MP 08_0016 Mod 1, 133 – 145 Lenore Drive, Erskine Park

Response to Agency Submissions

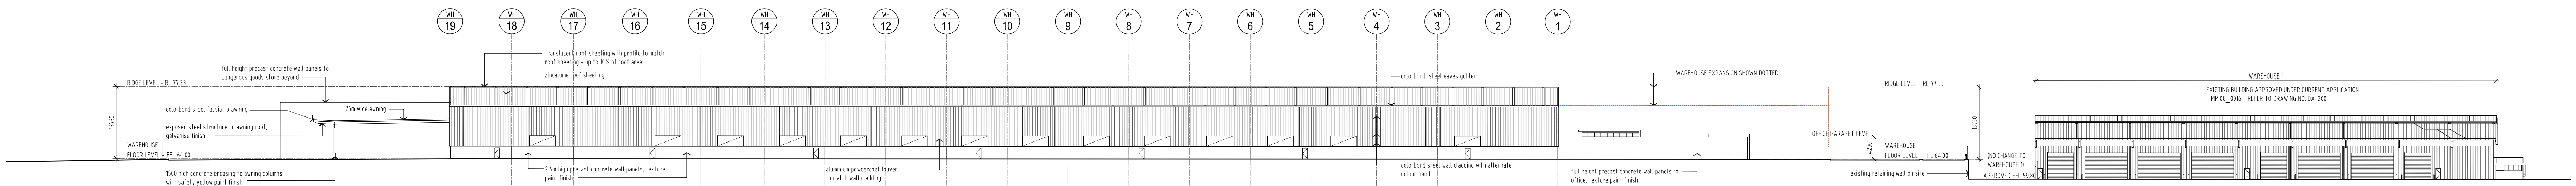
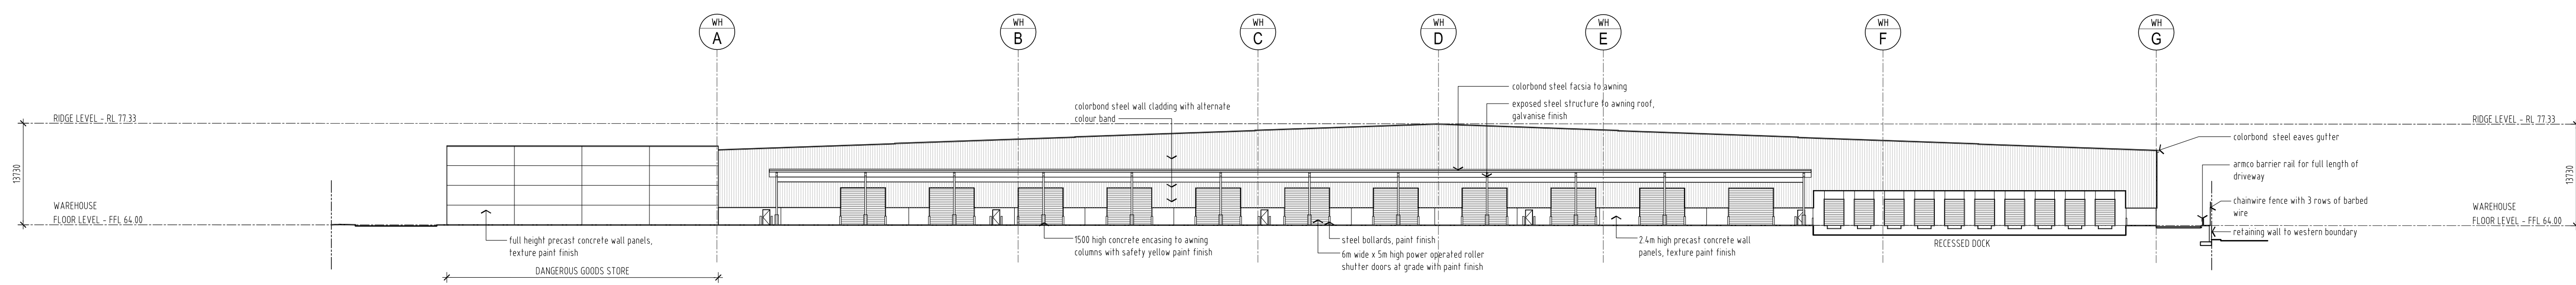
<i>Site Configuration</i> <i>The new proposal presents are poorer outcome in terms of presentation and setbacks to the northern and western boundaries. BCA compliance and NSW fire brigade acceptance of the reduced setback of the building to the western boundary, which appears to limit perimeter access, should be confirmed. The location of loading/unloading docks on the northern boundary presents concerns regarding</i>	The presentation to the northern boundary of the site is similar in building form and is setback <u>by up to 53 metres</u> further compared to the previous proposal from the northern boundary due to the shortening of the warehouse. The proposed roof pitch and building materials are similar to the approved design featuring concrete panels and colourbond metal cladding. The proposed northern elevation includes shutters to openings for the loading dock facilities and an awning to provide weather protection. These additional features are considered to be satisfactory to the northern elevation.

<i>acoustic impacts, visual amenity and lighting impacts on residents adjoining to the north.</i>	The acoustic impacts to the properties to the north will be managed in accordance with the Operational Noise Management Plan (ONMP), ensuring acoustic impacts are acceptable. The ONMP indicated that the proposal will comply with all noise criteria for all residences in the area for “evening” and “night time”, and concluded that <i>‘operational noise from the facility will comply with applicable noise criteria at all surrounding residences apart from a negligible 1 dB exceedance at 30 Regulus Street...’</i> and that based on the findings of the assessment the operation of the modified proposal was unlikely to impact adversely on the acoustic amenity of surrounding residences. The visual and lighting impacts will be mitigated by the increased setback to the northern boundary and the landscaping such as a landscaped buffer zone to minimise that is required to be provided as part of the original major project. In addition, the proposed FFL of 64.00 results in a ground level difference of up to 6m towards the northern end of the western elevation will contribute towards minimising the presentation of the building from the rear. The presentation to the western boundary of the site is similar in building form and adopts approved external materials of concrete panels and colourbond metal cladding. The presentation of this western façade will not be readily visible in the long term due to the construction of the Blue Star development immediately north of the site. While the western setback has been reduced, there remains adequate setback for a road along the western perimeter. The traffic report has assessed the suitability of the internal road for heavy vehicles and confirms that truck manoeuvring will be in accordance with AS 2890.1 and AS 2890.2. Swept path diagrams also illustrate that the internal road will accommodate 25m articulated trucks which will caters for the swept path of emergency vehicles. It is agreed that BCA compliance will be satisfied for the proposed setback to the western boundary.

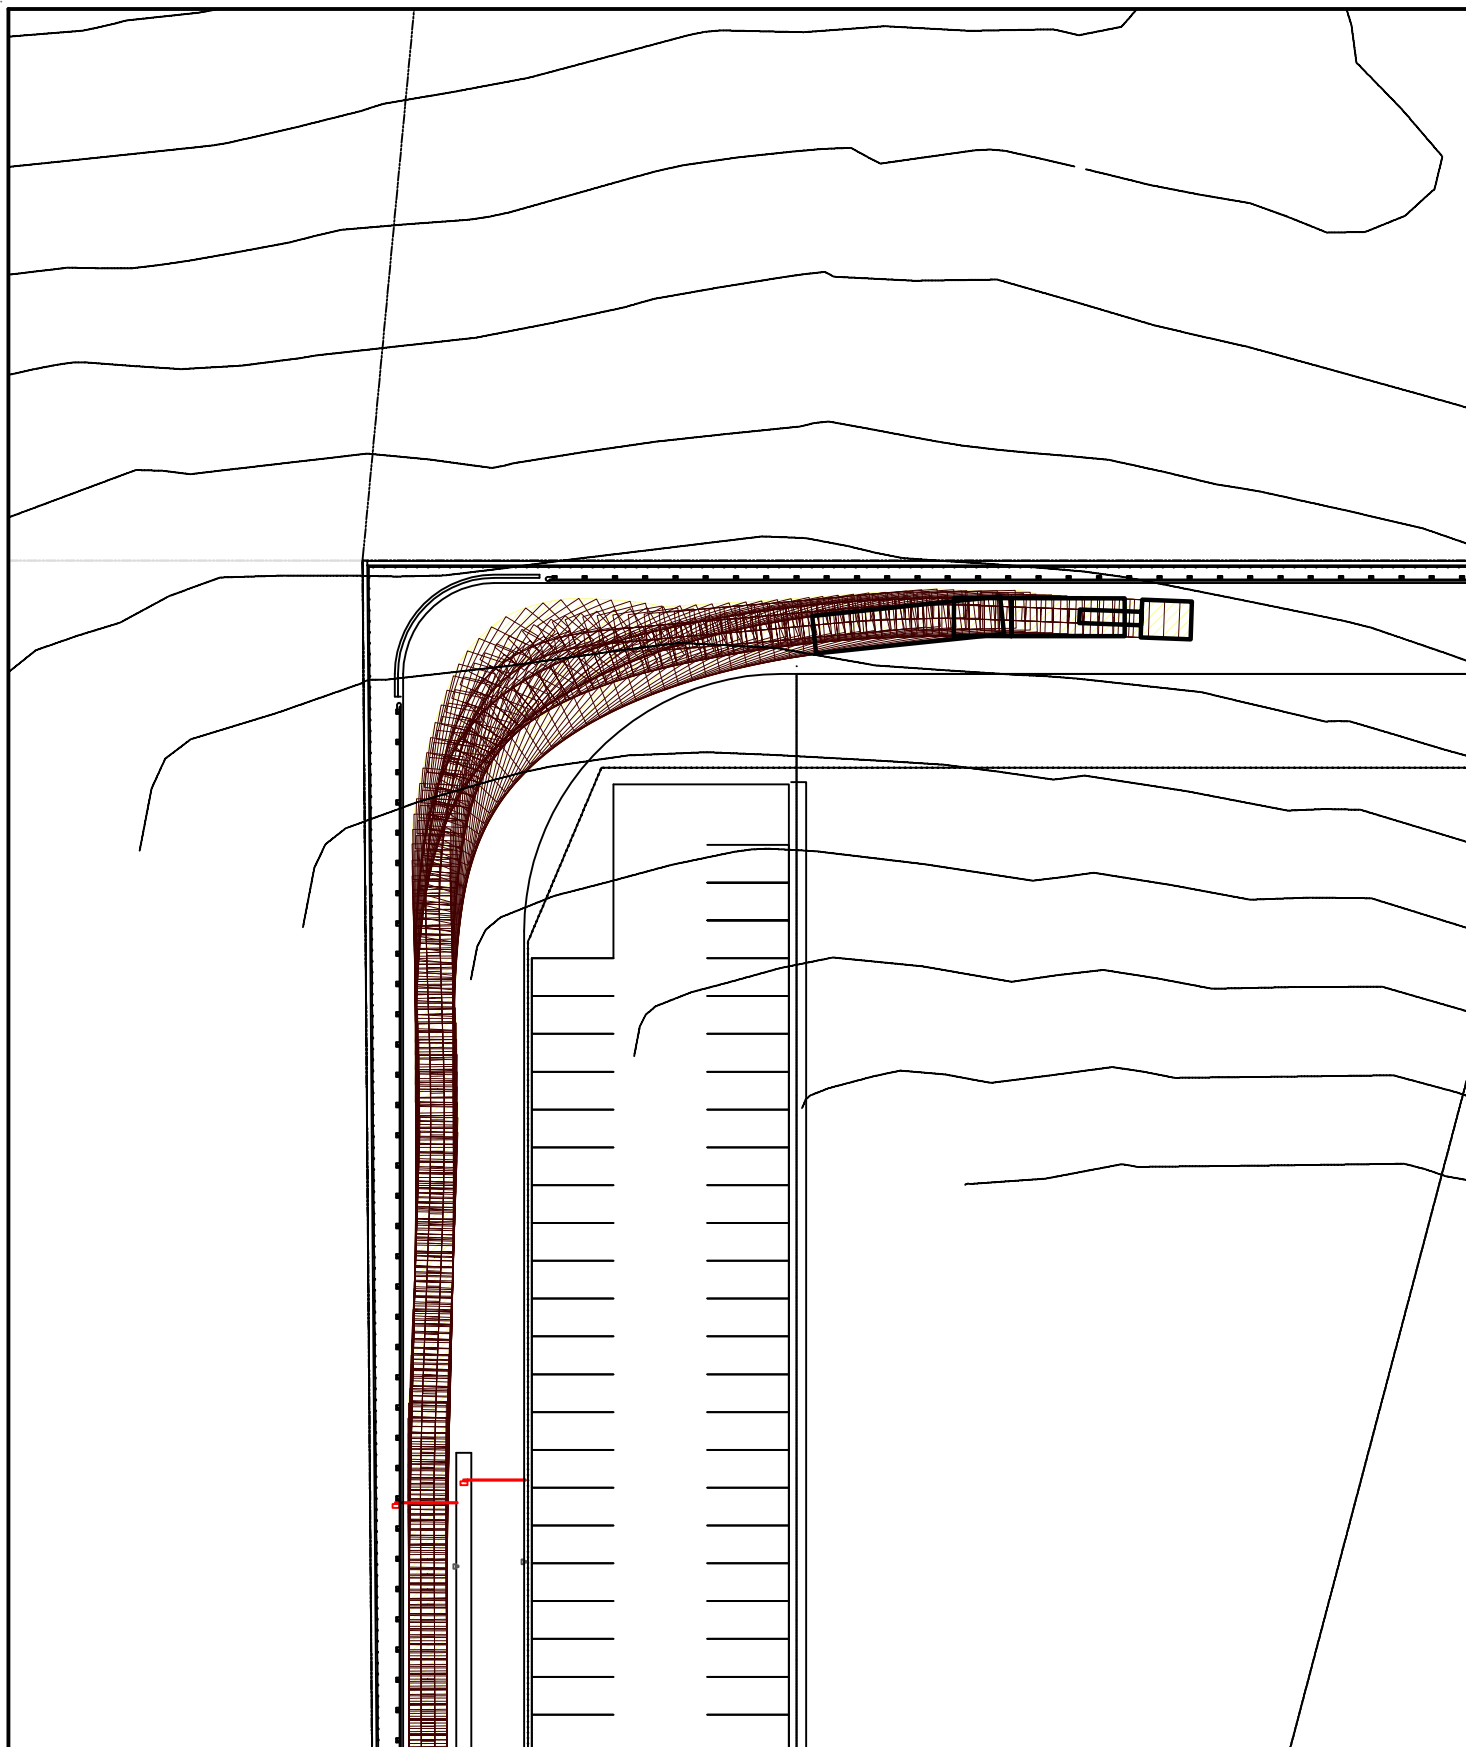
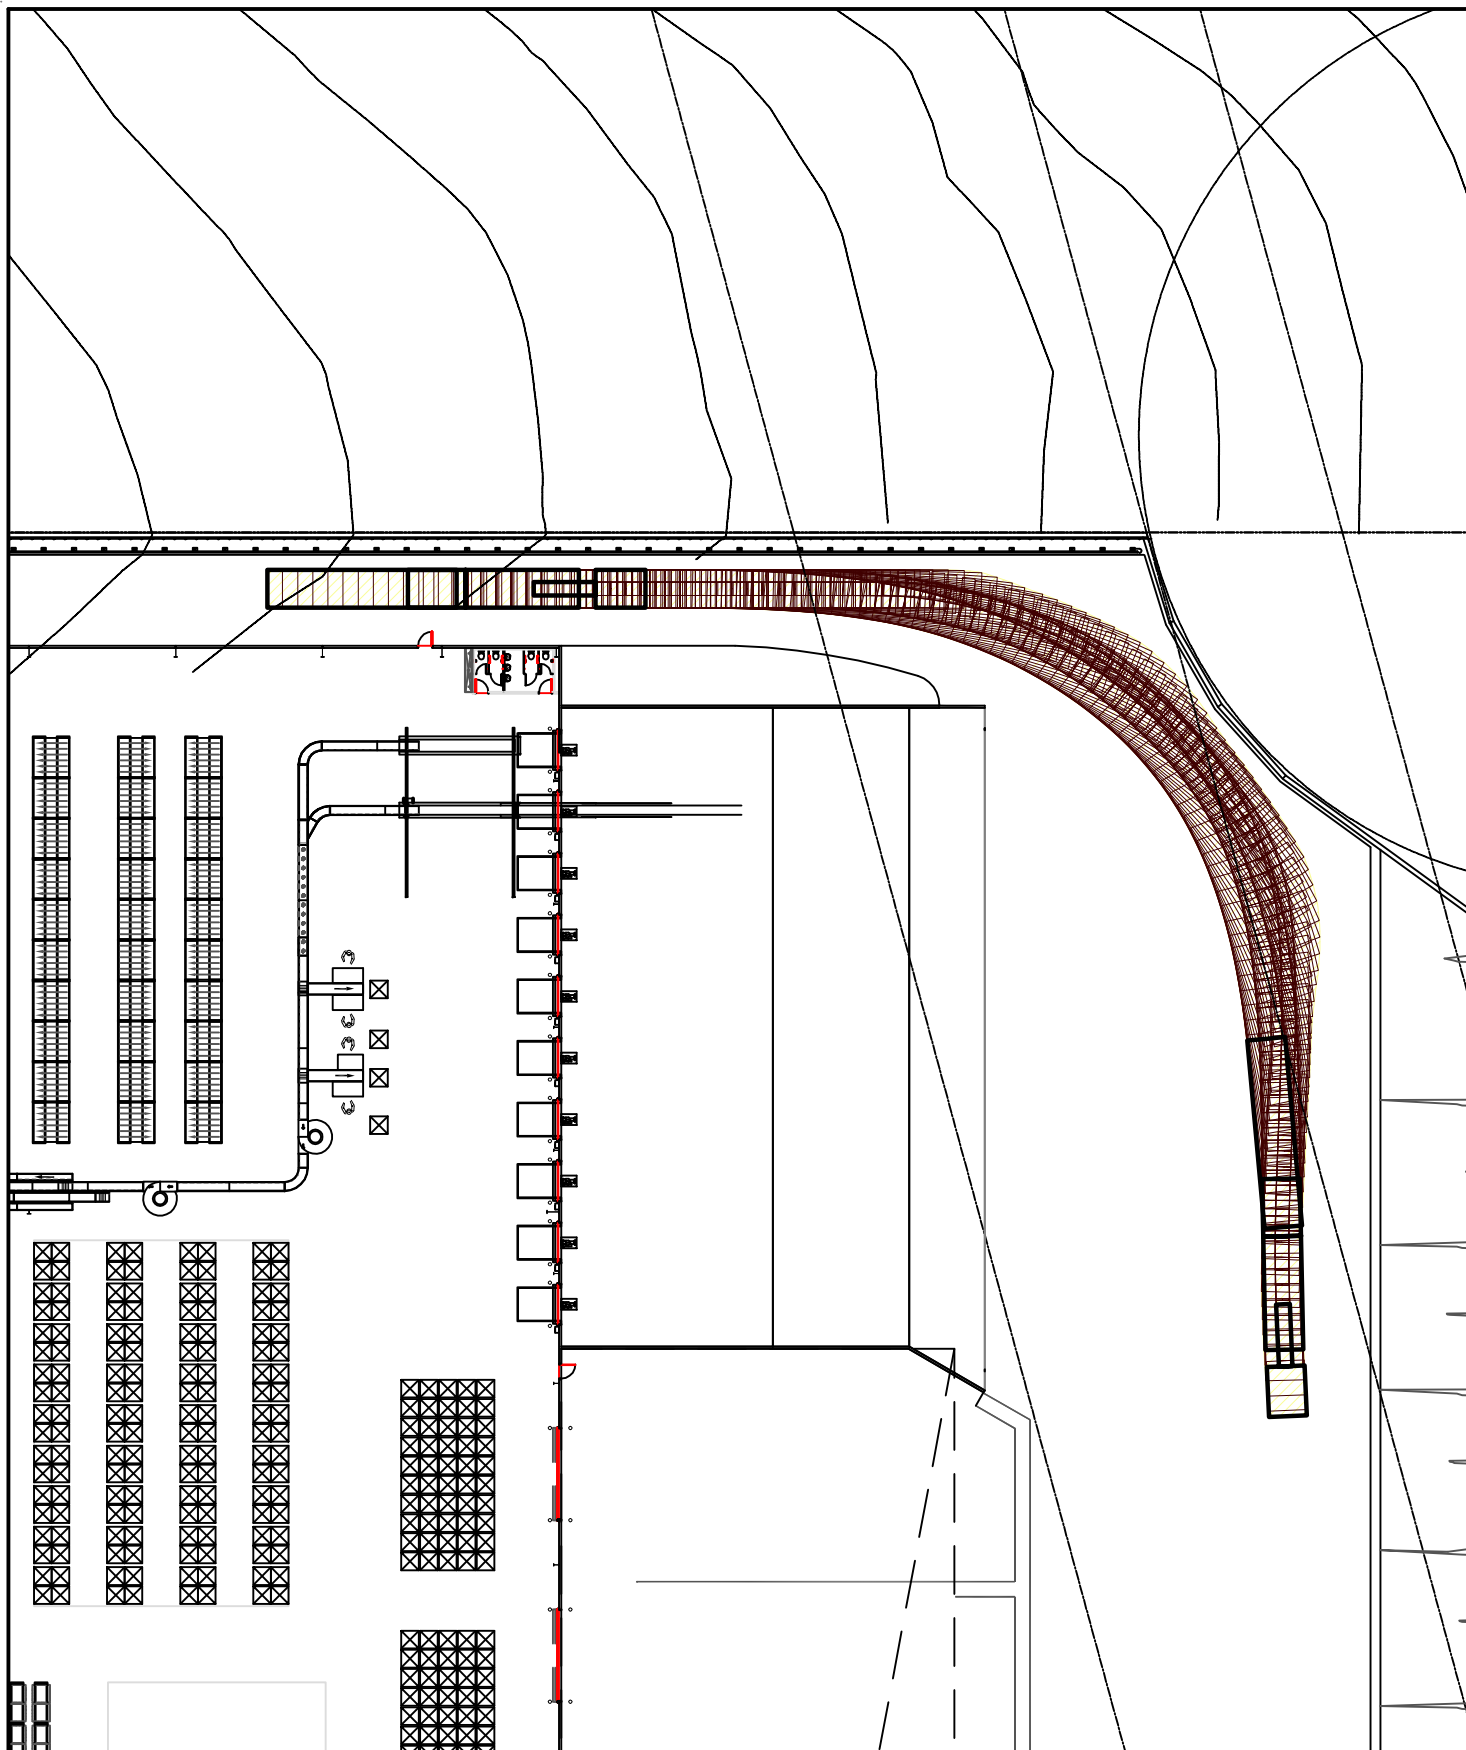
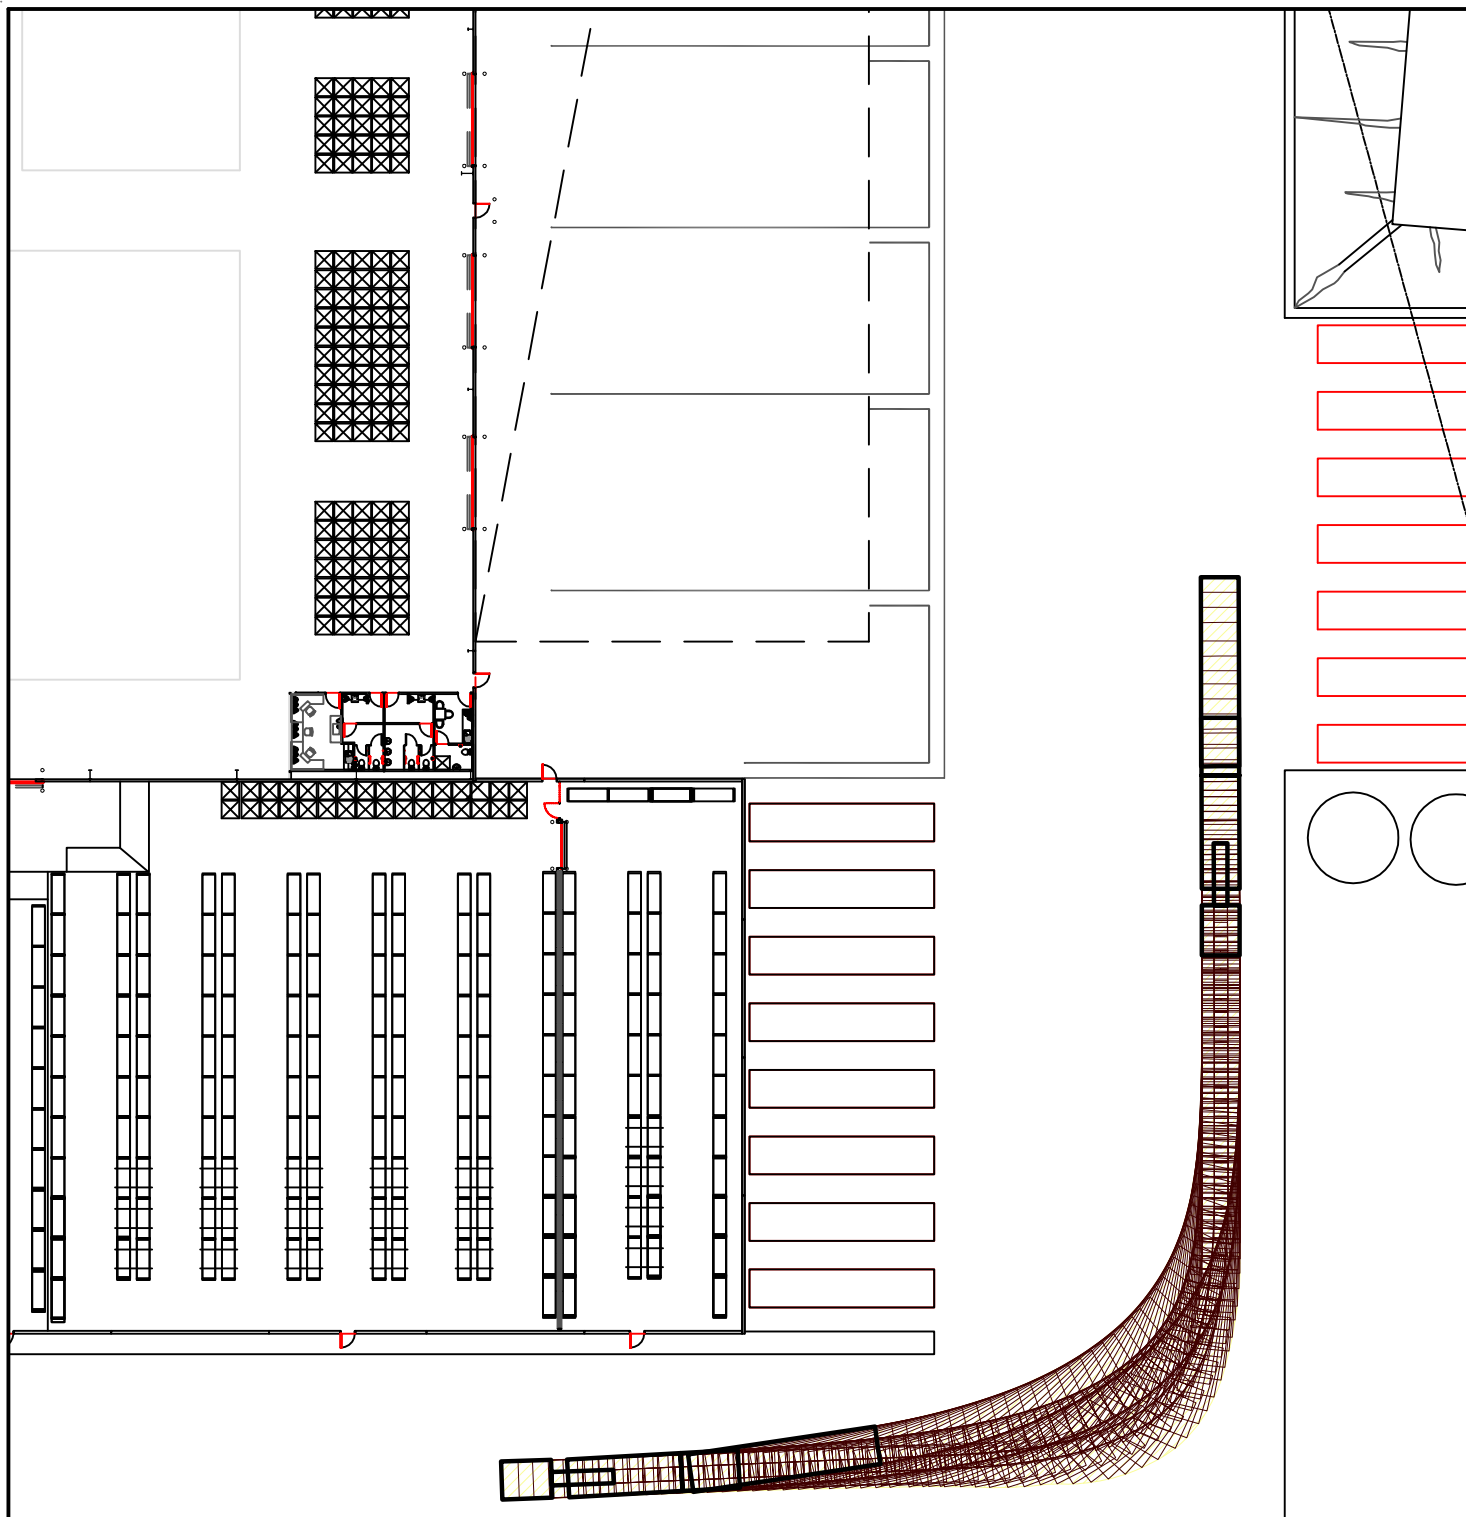
- Provision of directional line marking and signage be provided. - Provision of bicycle parking and facilities (including showers, change rooms, lockers). - Truck access points should be located to accommodate the turning path of a B-double for all movements on the correct side of the road/driveway for vehicles entering and exiting simultaneously. - Vehicles must be wholly contained onsite before being required to stop. - All vehicles must enter/exit the property in a forward direction. - All works associated with the development are to be at no cost to the RTA.	- Directional line marking and signage will be provided to guide heavy vehicles, staff and visitors to the appropriate site locations. - The current major project approval requires the provision of bicycle parking and associated facilities. - Driveways will accord with AS 2890.1 and 2 and will accommodate all B Double vehicles. - Truck access points are designed to appropriately accommodate B Double vehicles (refer to Attachment A). - All vehicles will be able to be entirely within the site before stopping and will be able to enter and depart in a forward direction. Truck turning paths showing the satisfactory provision for access movements are provided in Attachment B of this letter). - No costs will be borne to RMS.
